# Rezoning Transportation Analysis

Petition Number: 2022-151

General Location Identifier: 02711418

## Revision Log:

DRAWING NUMBER:
RZ-1

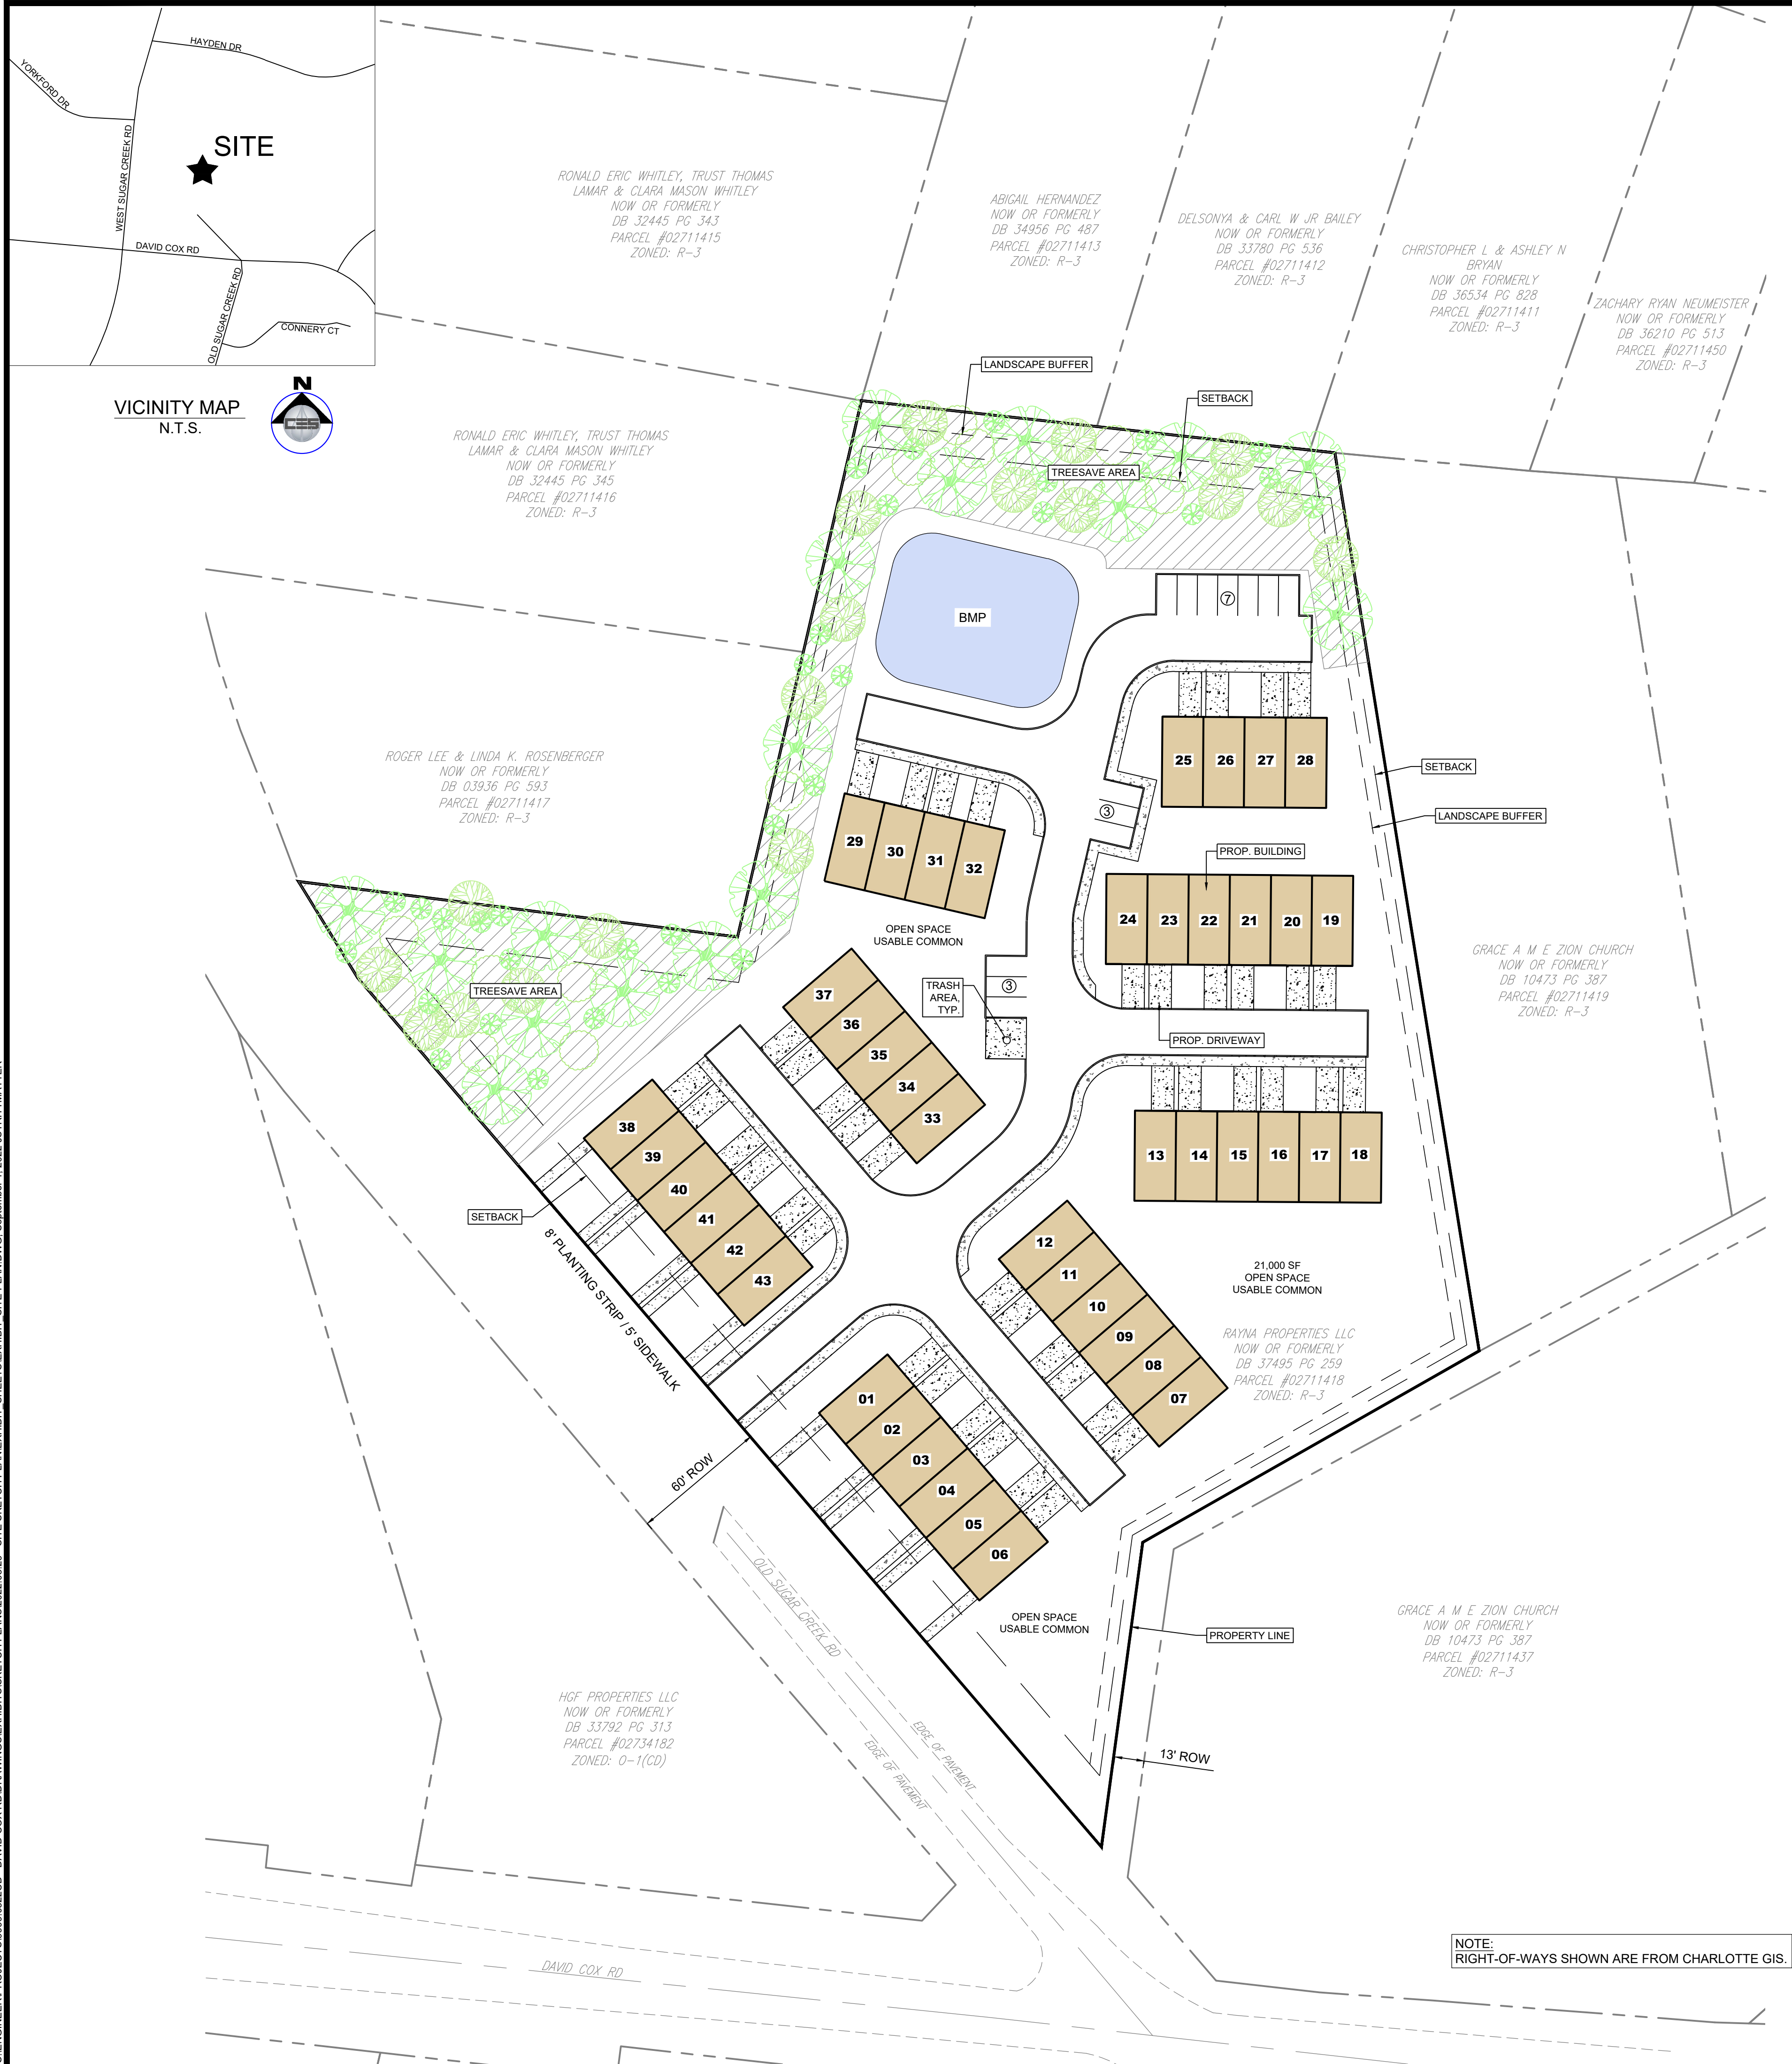
- David Cox Road:** Location of future back of curb and gutter to be 19-feet from roadway centerline to accommodate the Charlotte Streets Map with a roadway typical section following that of 11-09 Minor Thoroughfare.

**Outstanding comment from 01-25-23:** Label and dimension the curb and gutter from the centerline for each road on the site plan.

**Clarifying Comment 03-23-23:** Revise site plan by labeling the proposed public street extension per CLDSM U-02, dimension back of curb from roadway centerline and add dimensions of sidewalk on site plan.

11. **NEW COMMENT 04-20-23:** Revise conditional notes by modifying the conditional notes to reference the proposed roadway in lieu of Old Sugar Creek conditional notes as Old sugar creek is to be abandoned (see above comments regarding abandonment). Conditional notes are to reference the proposed roadway and not Old Sugar Creek.

12. **NEW COMMENT 04-20-23:** Revise site plan to remove extension of private streets to property line.
